Date 08 May 2017

**RE: 6/2016/2675/MAJ - Queenswood School, Shepherds Way, Brookmans Park, Hatfield, AL9 6NS**

We understand this application seeks full planning permission for a major development, and we have assessed the Surface Water Drainage Strategy dated 13 April 2017, submitted in support to this application. However the information provided to date does not provide a suitable basis for an assessment to be made of the flood risks arising from the proposed development.

We therefore object to the grant of planning permission and recommend refusal on this basis for the following reasons.

Figure 5: SUDS Strategy

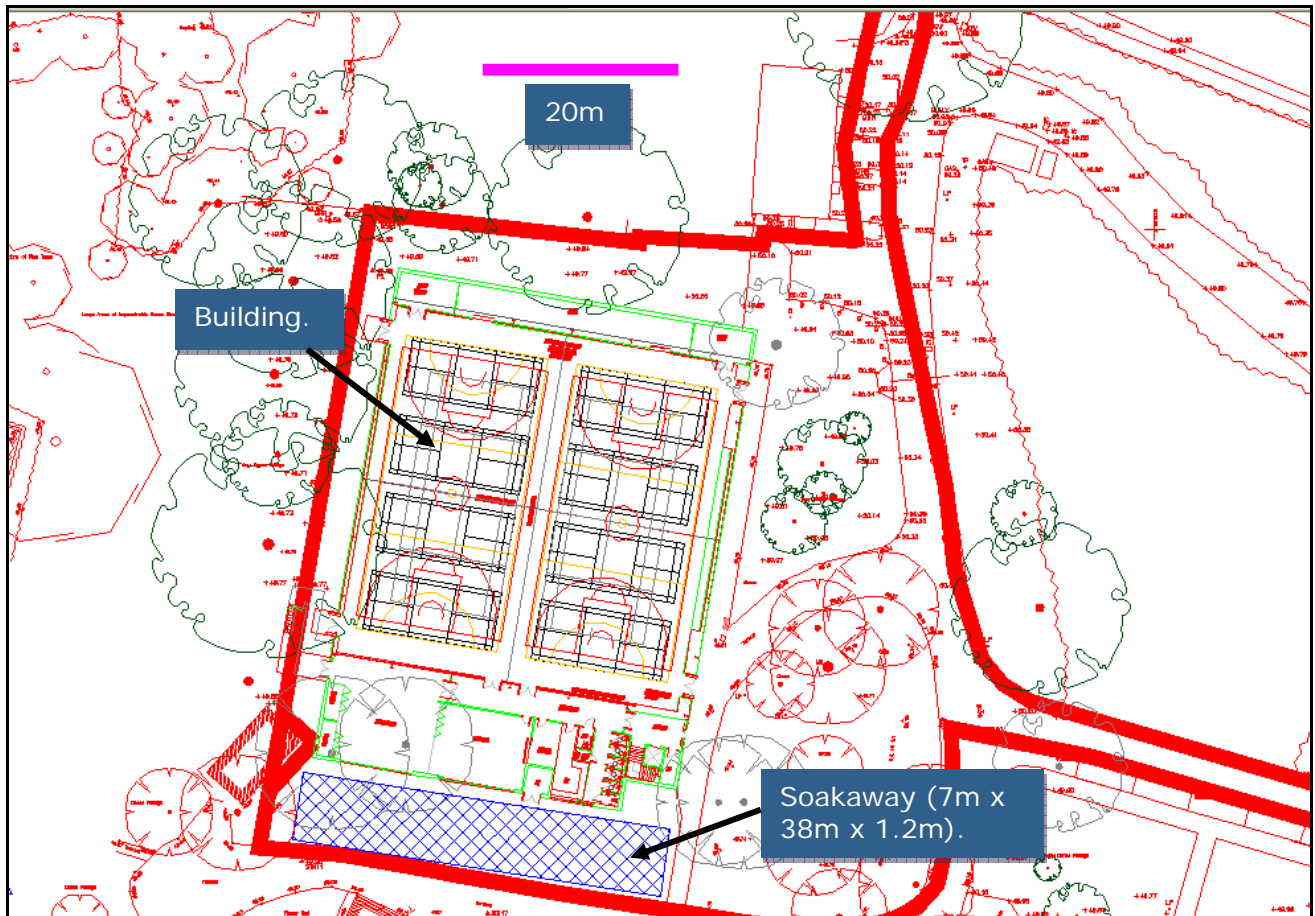
3. We acknowledge that the applicant has provided a surface water drainage strategy layout with a detention basin and a hydrobrake location. We require a drainage plan for all the development site. We would like to know what the size of proposed detention basin is. We require information about the exact location of the discharge point into the watercourse, what the condition of this watercourse is and if it has the capacity to take the additional flow from the proposed development. As the scheme proposes a detention basin, without information about the discharge point we are not able to establish the feasibility of the proposed drainage strategy.  
The drainage system should be designed to accommodate all surface water up to and including the 1 in 30 year rainfall return period. For the 1 in 100 year rainfall event informal flooding on the development site can occur, however it needs to be shown on a map and it cannot flood the building.

5. We acknowledge that the applicant undertook infiltration tests. However, as a detention basin is proposed, we need to know where boreholes are located and where is the location of the highest groundwater level. We would require information about groundwater levels at the location of the basin.
6. The applicant will need to satisfy the LPA that the proposed drainage scheme can be adopted and maintained for its lifetime by providing a maintenance plan, detailing key operations and management. The maintenance of detention basin structure must be appropriate to prevent the risk of failure or reduction of its capacity.
